13 December 2015

Re: SCECGS Redlands School Concept Proposal and Stage 1 Development; SSD 6454.

Revised Design
Additional setbacks +
relocate pool to basement

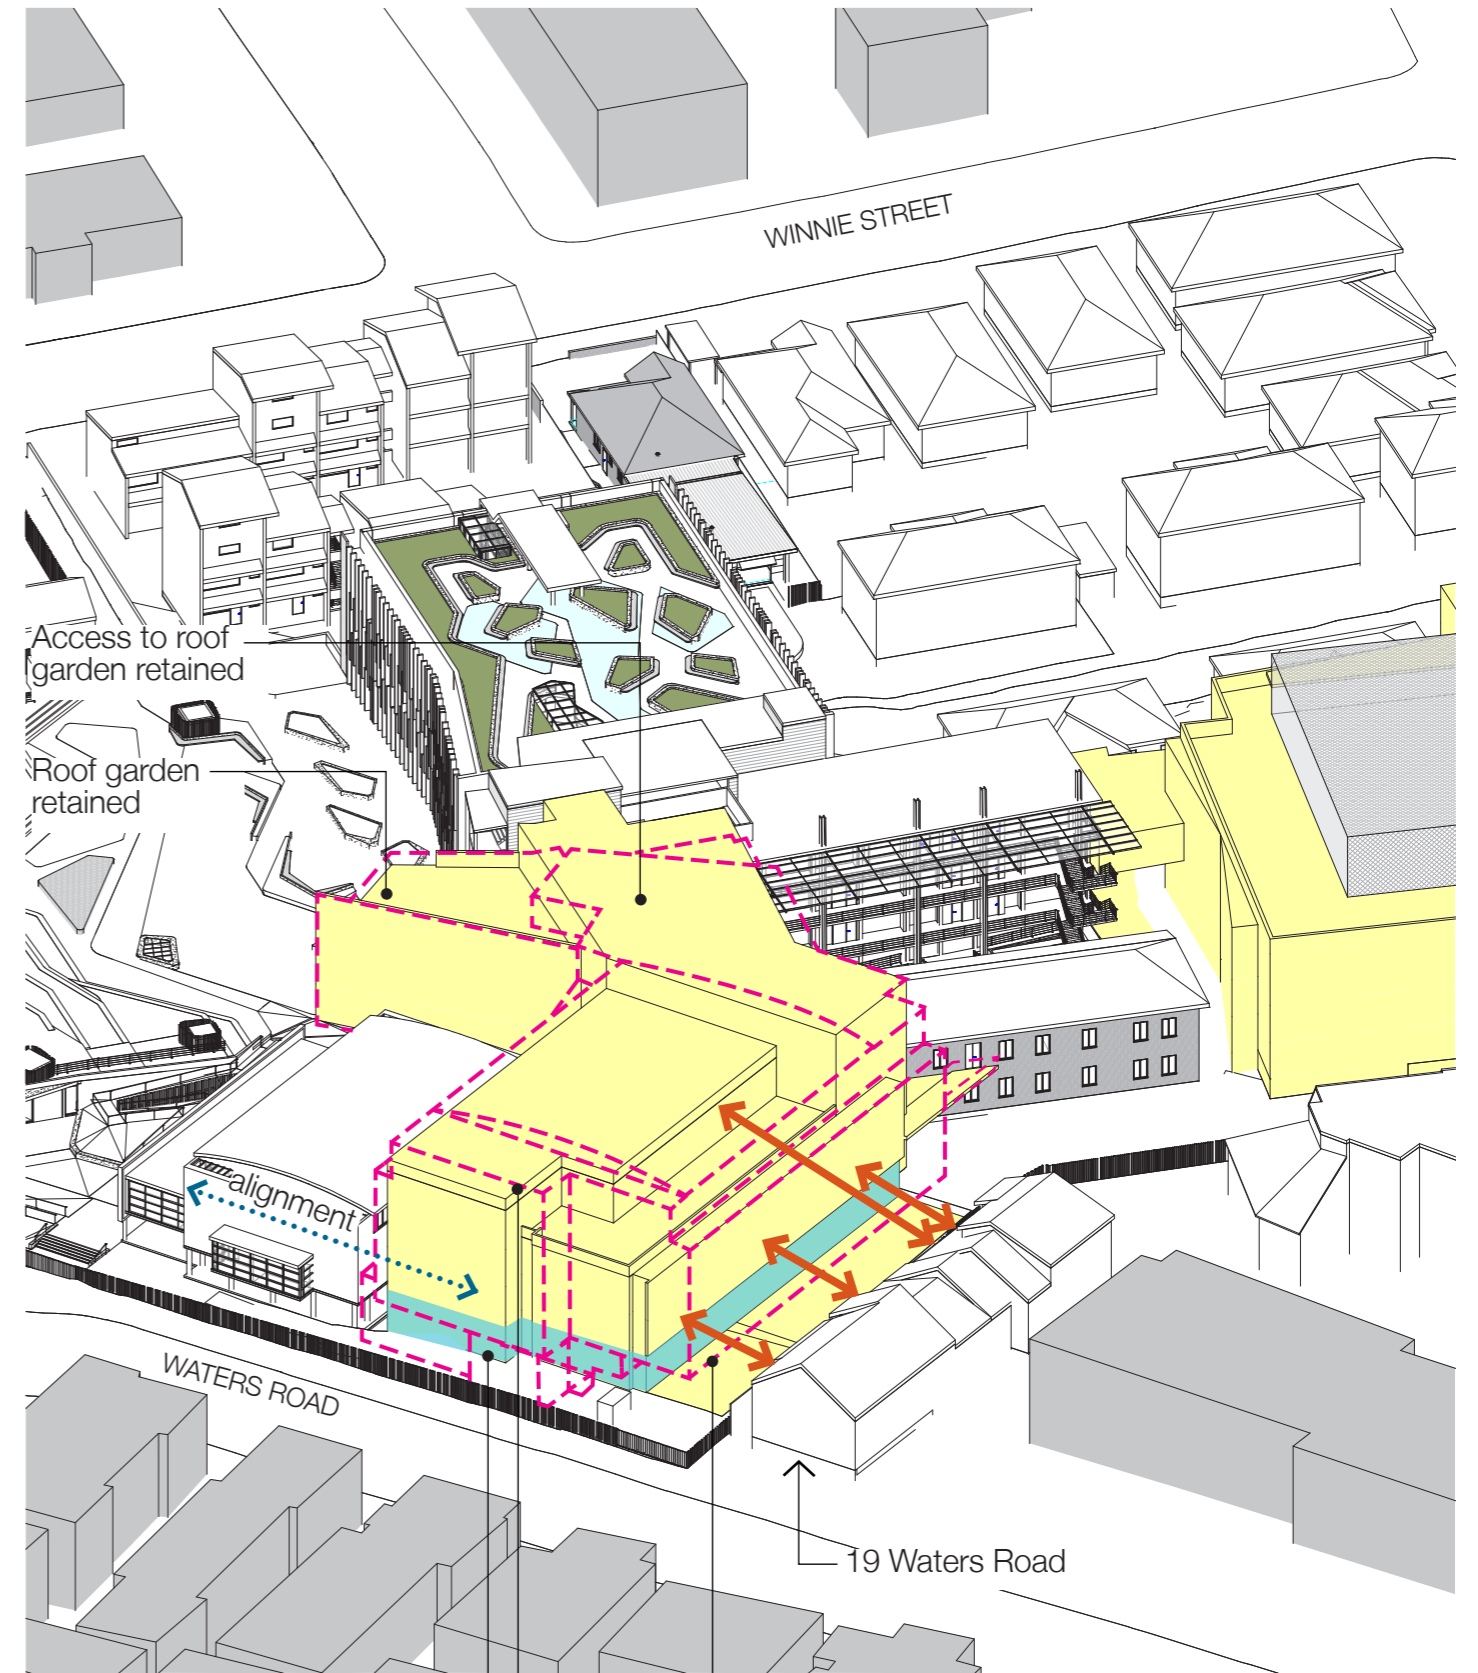
The proposed Humphrey Building has been reduced, though it is still non-compliant with North Sydney Council height restrictions. It is 22.55 metres high, in an area that has a 12 metre height limit – this is approximately 87% too high. I find the requests for the height exemption to be weak. I oppose the school being allowed non-compliance just so it can “develop the facilities required by the School on a single site” (in other words – just to conduct its business). There are higher buildings nearby, but they lack a neighbouring proximity to the school. Further, we can achieve “improvements to the physical appearance of the site through a carefully designed building that is responsive to site context and its intended function” whilst maintaining compliance. I also question that reducing the scale of the development would “undermine the visual quality of the design” - I would expect visual quality of a design can be maintained regardless of scale. Finally, if non-compliance is the only means by which the school’s “accommodation requirements” can be met, then a review of those requirements should be undertaken.

The swimming pool of the Humphrey Building has been moved to the basement of that building. Noise will continue to emanate from the basement when the pool is being used. I have reservations about the enclosure being able to suppress all generated noise associated with pool operation such as sports whistles and spectators. That usage will include training sessions that commence at 6am or earlier, along with carnivals that will occur on weekends.
